# CITY OF ALBUQUERQUE

January 2, 2024

**Re: Children's Promise Centers**  
**401 Alvarado Dr. NE**  
**30-Day Temporary Certificate of Occupancy**  
**Transportation Development Final Inspection**  
Architect's Stamp dated 08-04-22 (K18-D022)  
Certification dated 11-29-23

Architectural Site Plan

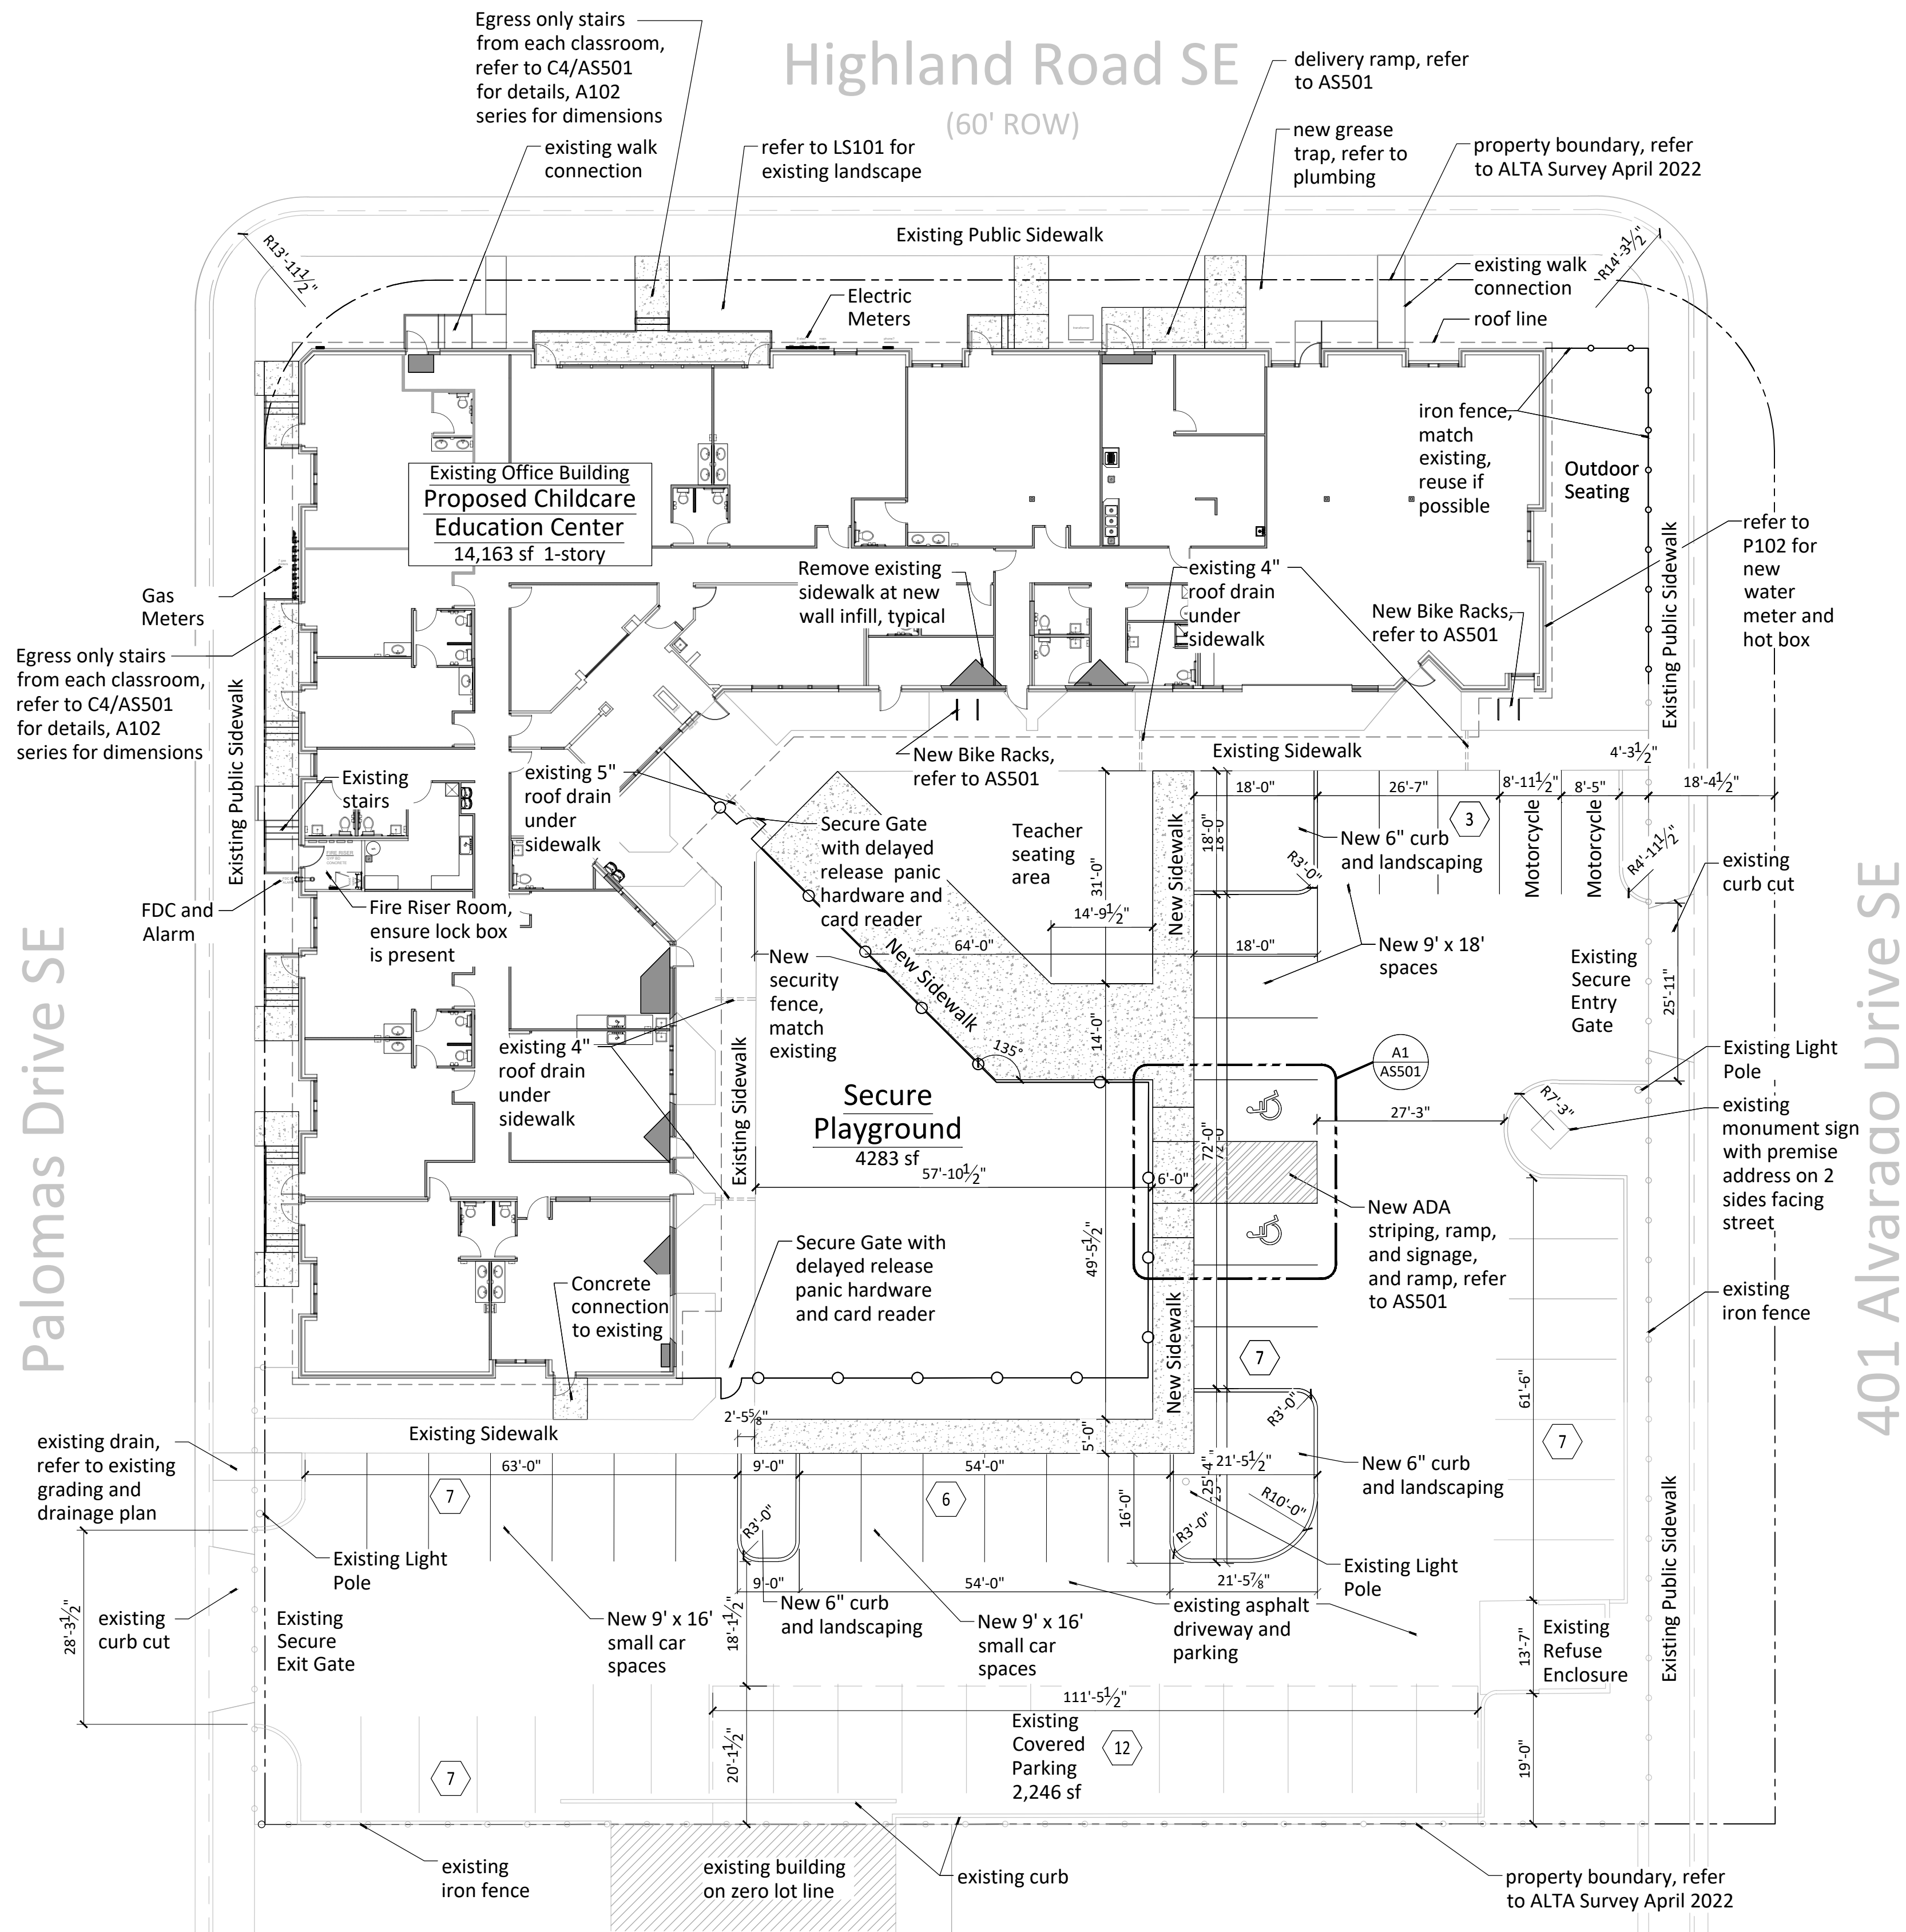
- Please review the approved plan dated on the Traffic Certification. The Architect Stamp is dated 08/04/22.
- Please fix the concrete cracked on the public sidewalk on the eastside of the site off Avarado Dr.

- Site accesses and public ADA curb ramps at the corner of Alvarado & Highland Rd. and at Highland & Palomas Dr. must be updated to current standards and have truncated domes installed.
- Please provide sidewalk easement for the sidewalk off Alvarado Dr. as mentioned in the approved TCL letter.
- Per approved site plan, please provide two Motorcycle parking spaces and the pavement marking "MC" should be shown in the opposite direction for motorcycles entering the parking space.
- Anchor down the bike rack.
- Tripping Hazard: sidewalk and landscape area at the south side of the playground must be at the same elevation.

- Please provide 6 ft. wide ADA pathway from the public sidewalk to the building entrance.

A1 Typical ADA Parking Space
1/4" = 1'-0"

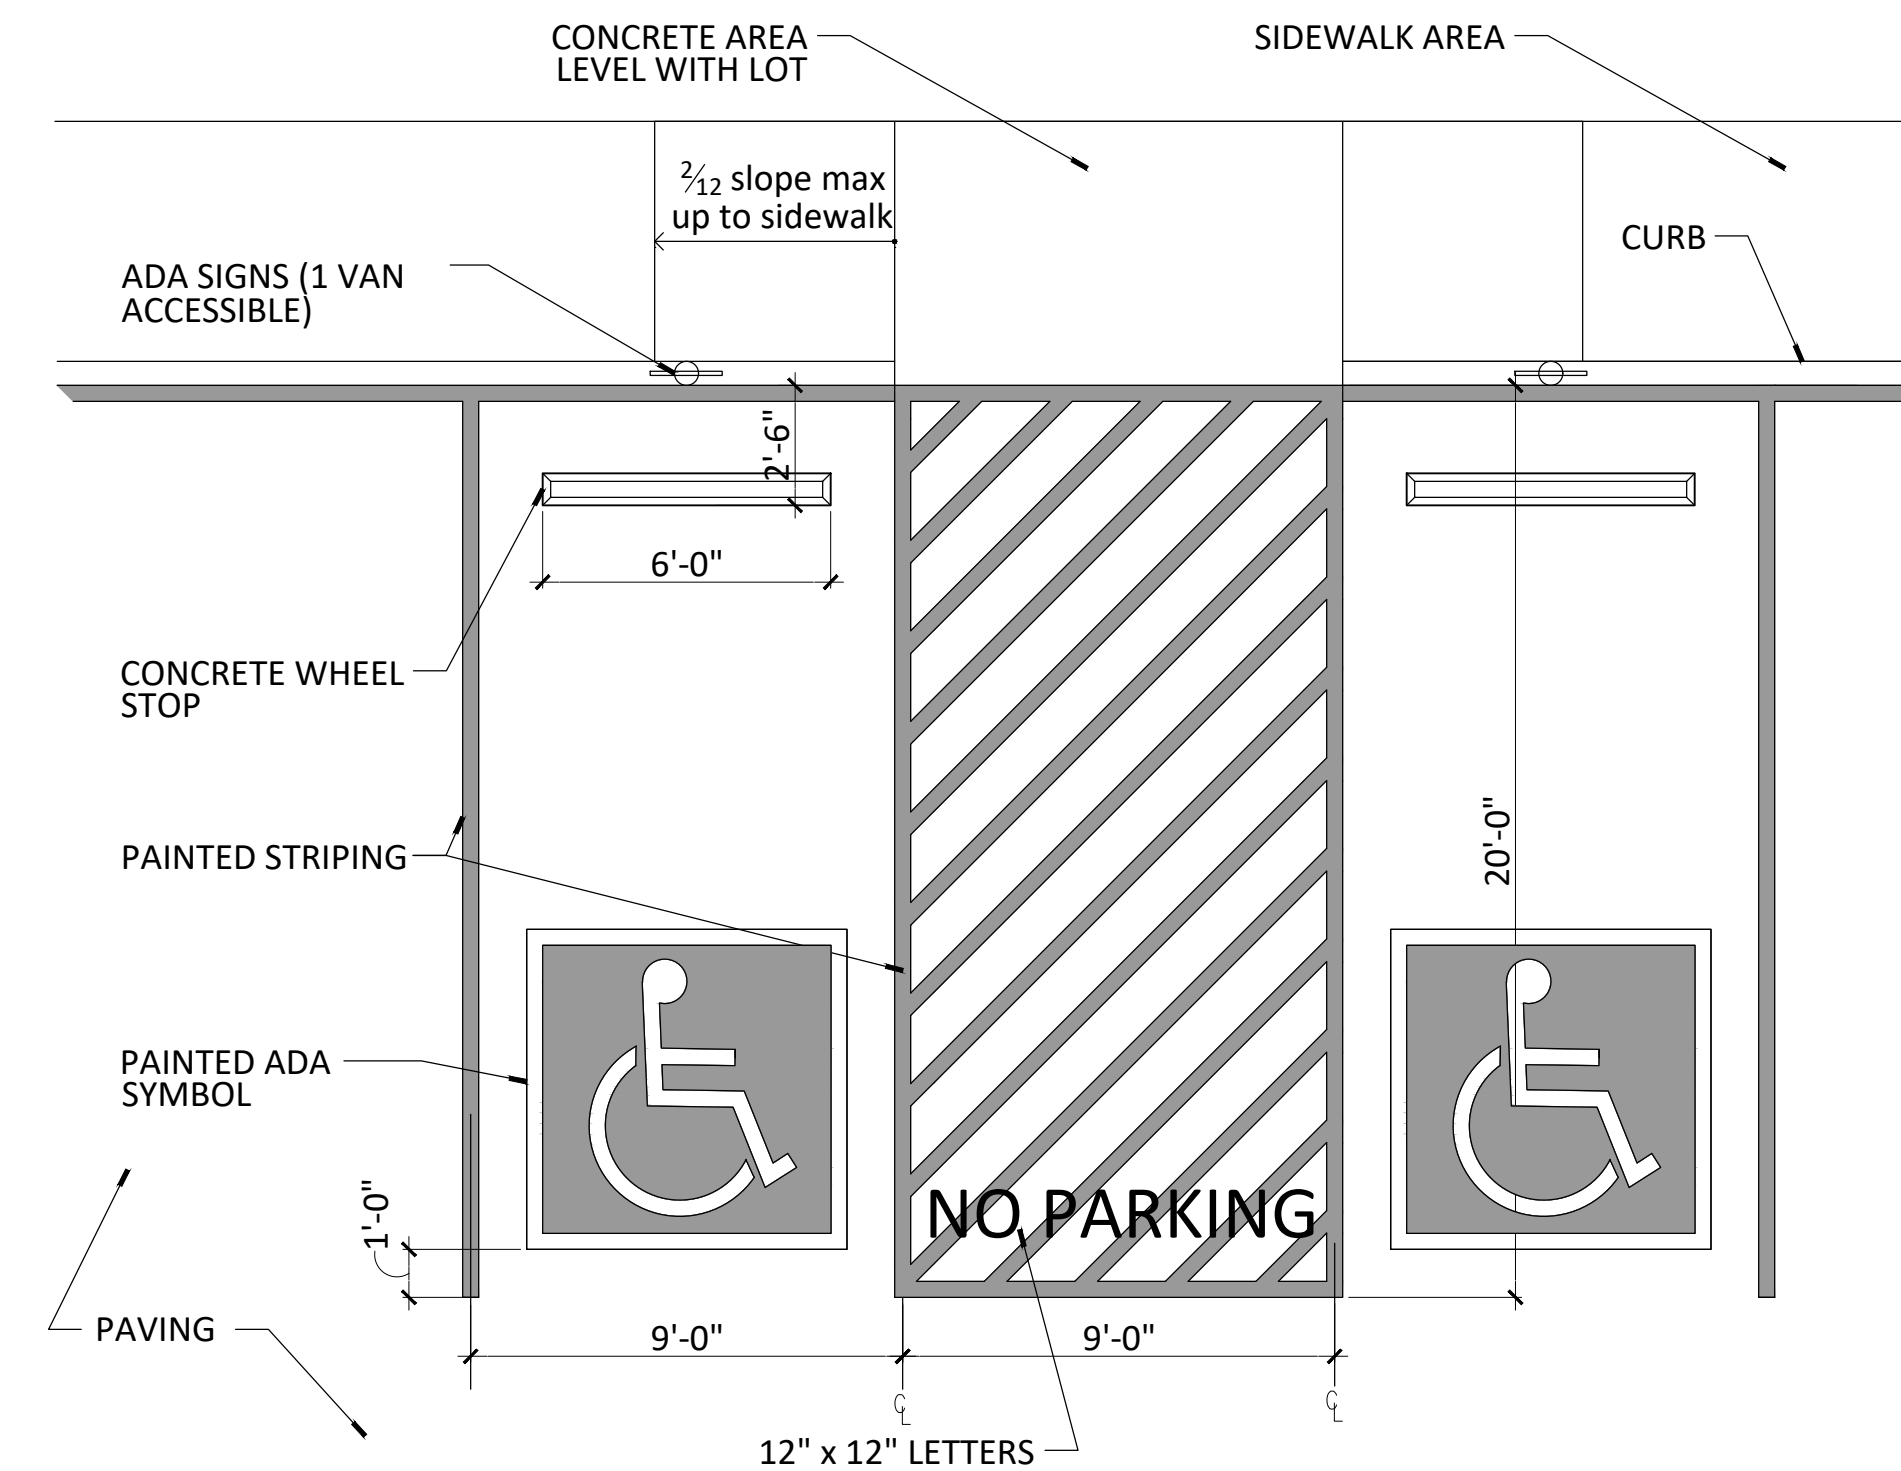
- The ADA accessible parking sign must have the required language per 66-7-352.4C NMSA 1978 **"Violators Are Subject to a Fine and/or Towing."**
- The ADA access aisles shall have the words **"NO PARKING"** in capital letters, each of which shall be at least one foot high and at least two inches wide, placed at the rear of the parking space so as to be close to where an adjacent vehicle's rear tire would be placed. (66-1-4.1.B NMSA 1978)
- Per site visit, this ramp does not comply with ADA standards. Please install an ADA compliant ramp that meet the ADA regulations (max. running slope should not exceed 8.2%).
